DRB Application No.: 05DRB-00780 (SBP)  
Project Name: OAK STREET CONDOMINIUMS  
Agent: DESIGN PLUS LLC

**TO:** Sheran Matson, DRB Chair  
**FROM:** Carmen Marrone, Senior Planner  
**RE:** Project #1003715, Oak Street Condominiums

**DRB CASE NO/PROJECT NO: 1003715**

Michael Helton
 SITE PLAN

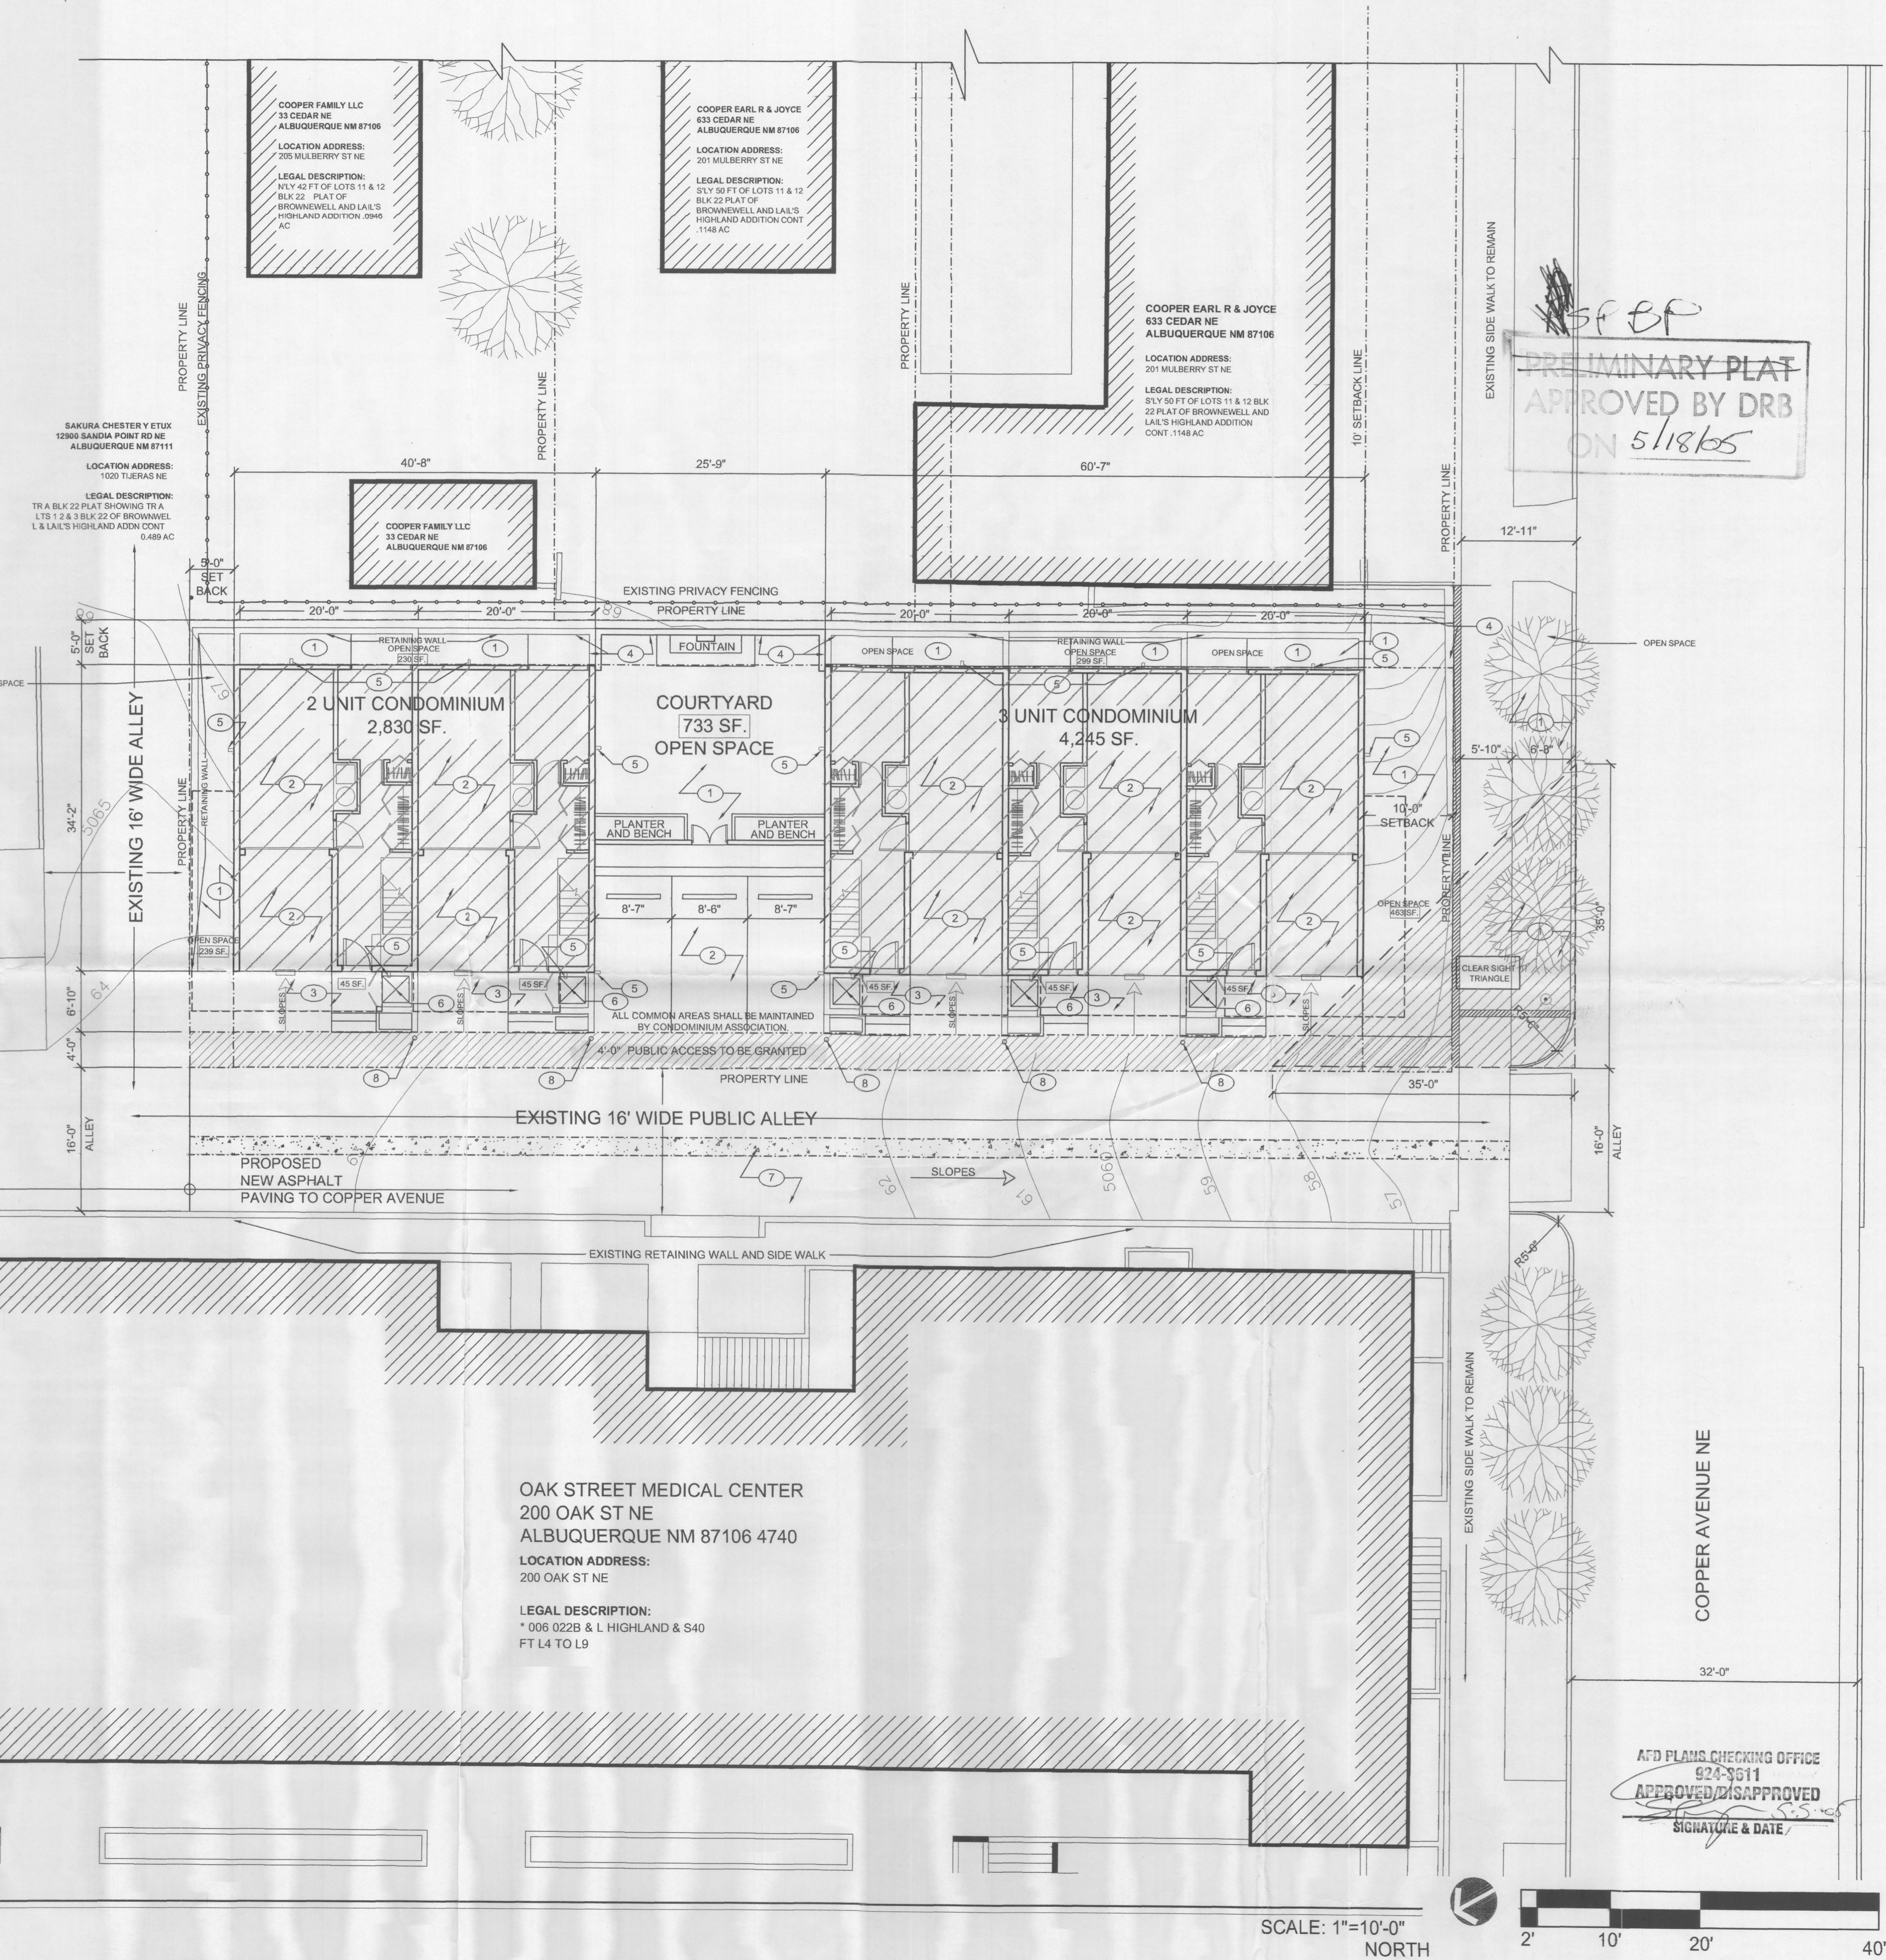
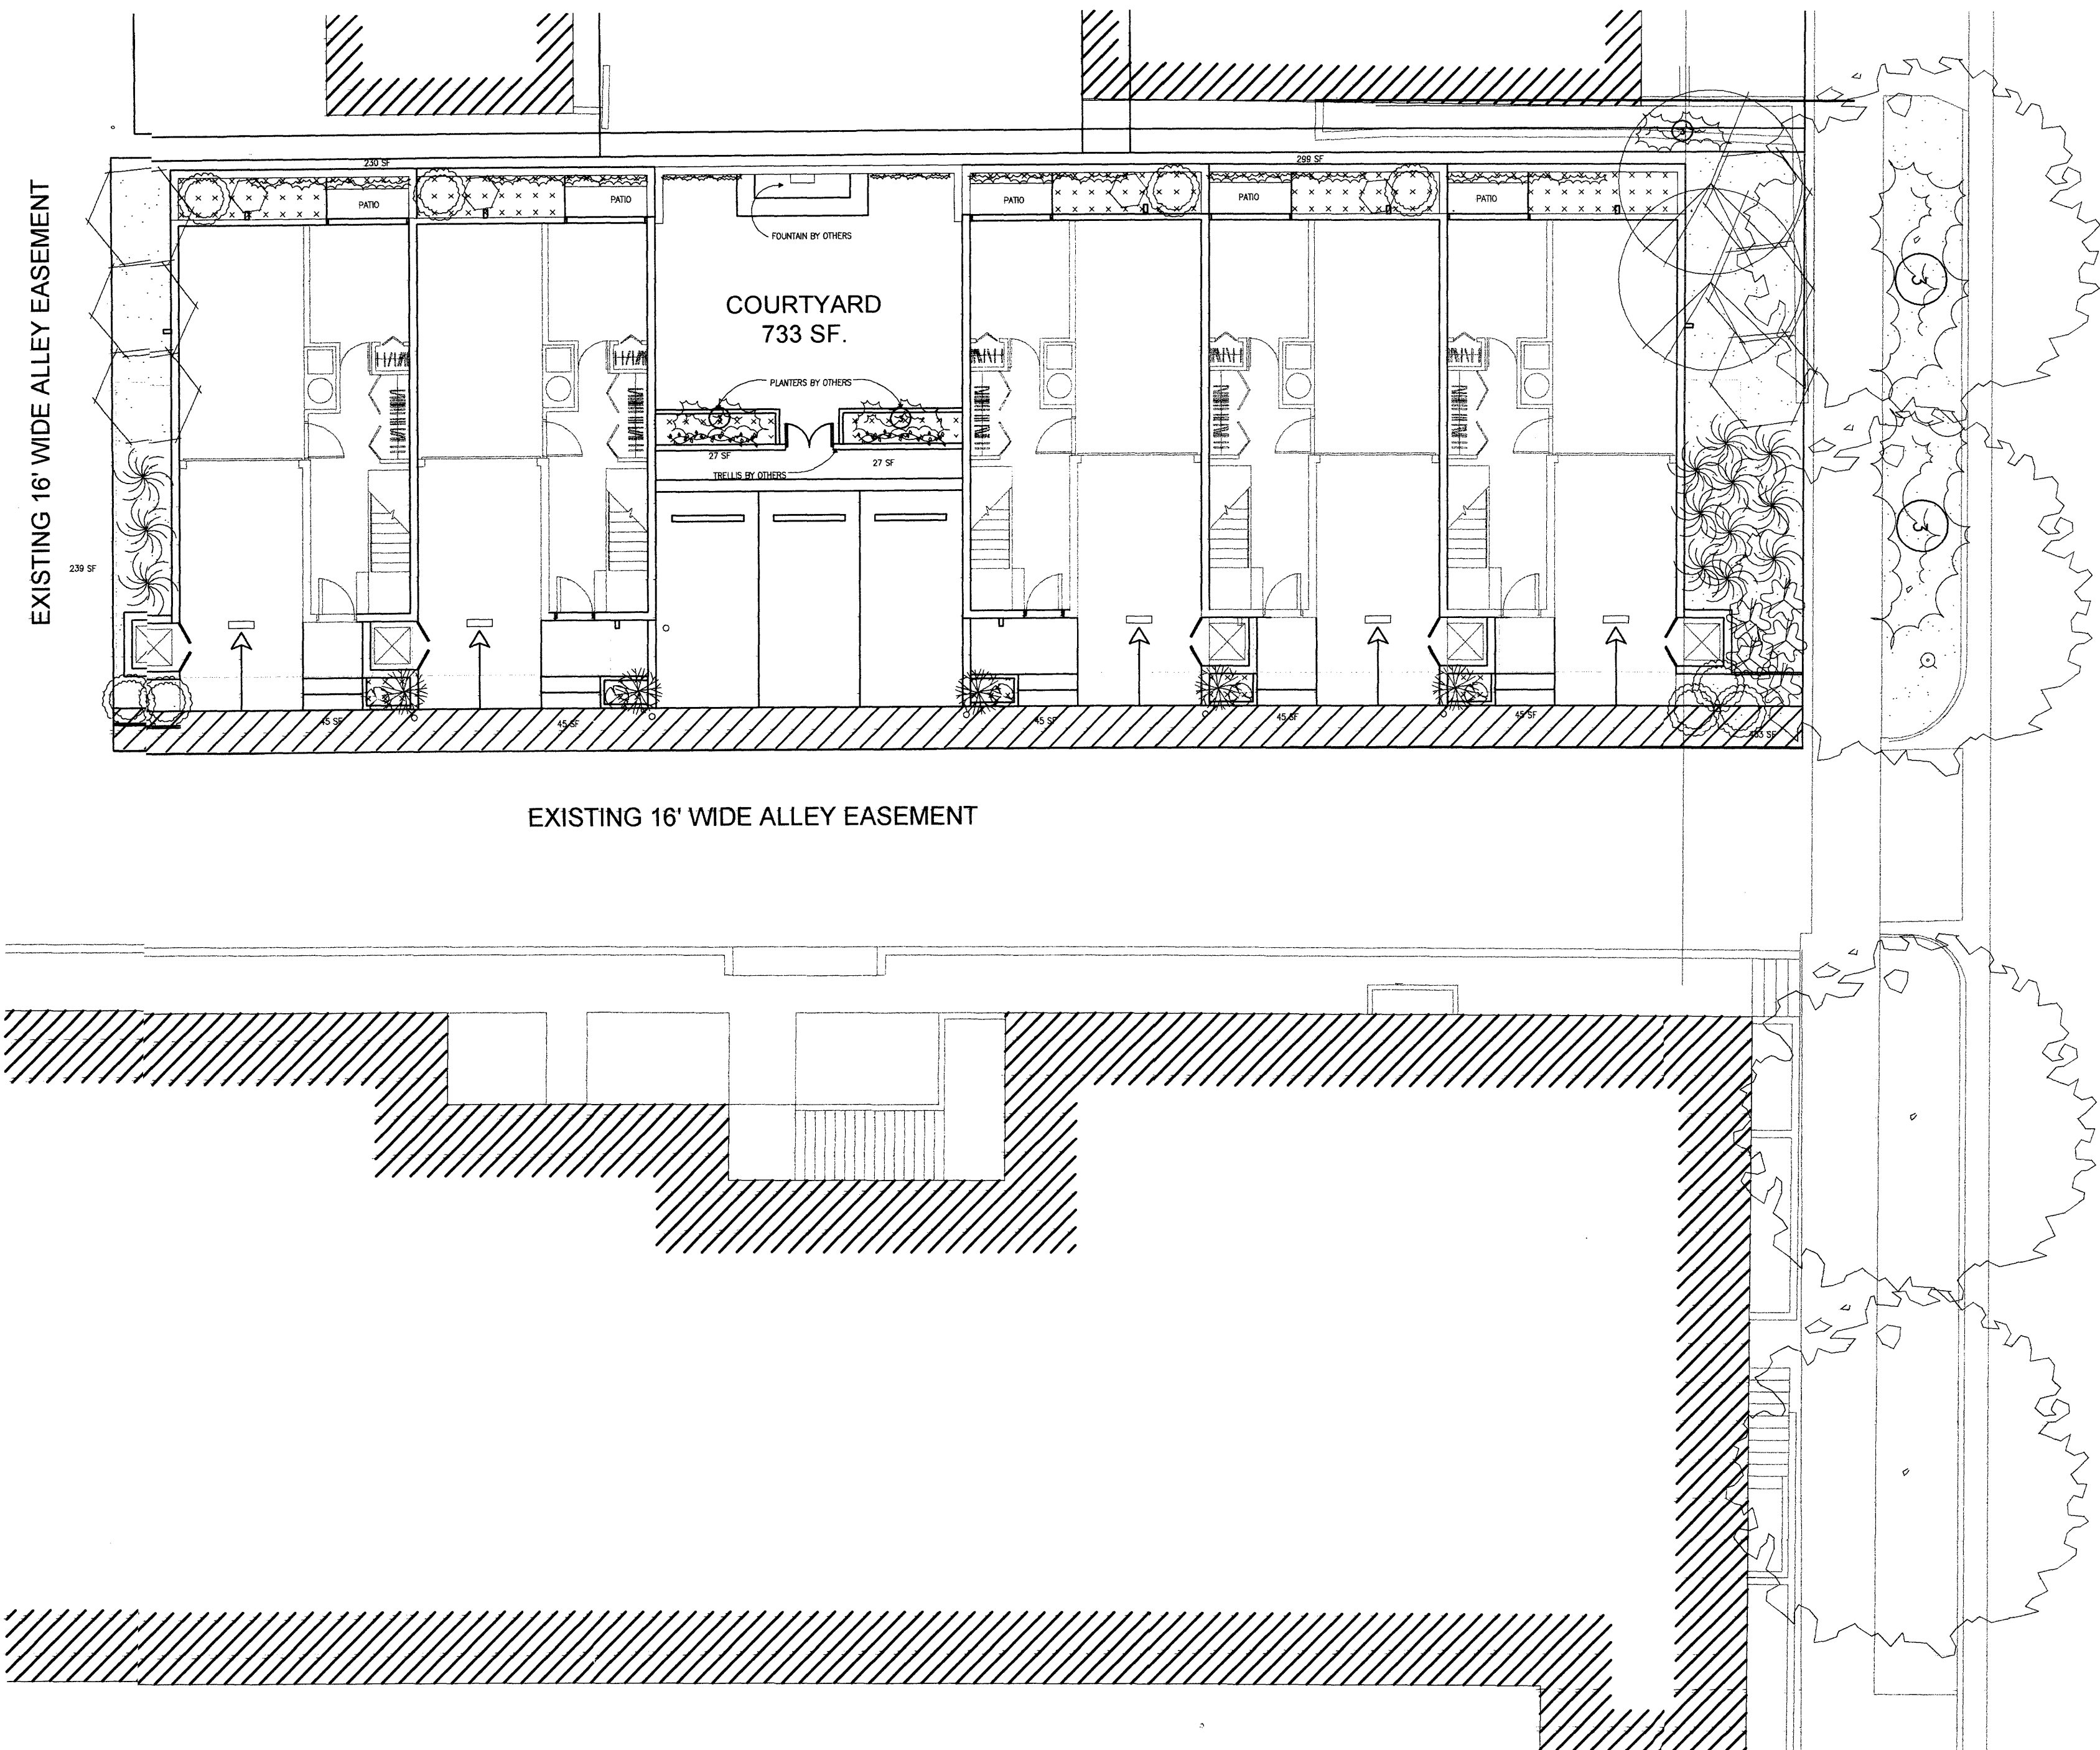
Condition 4: Revise "Usable Open Space Calculation" note to read, "(Usable open space shall be provided in accordance with the R-2 Zone)"  
Required: 600 sq. ft. for each 3-bedroom unit x 5 units = 3,000 sq. ft.  
Provided: ...

Condition 17: The site plan shows three street trees along Copper Avenue while the landscape plan shows two street trees. Revise the site plan to match the landscape plan.
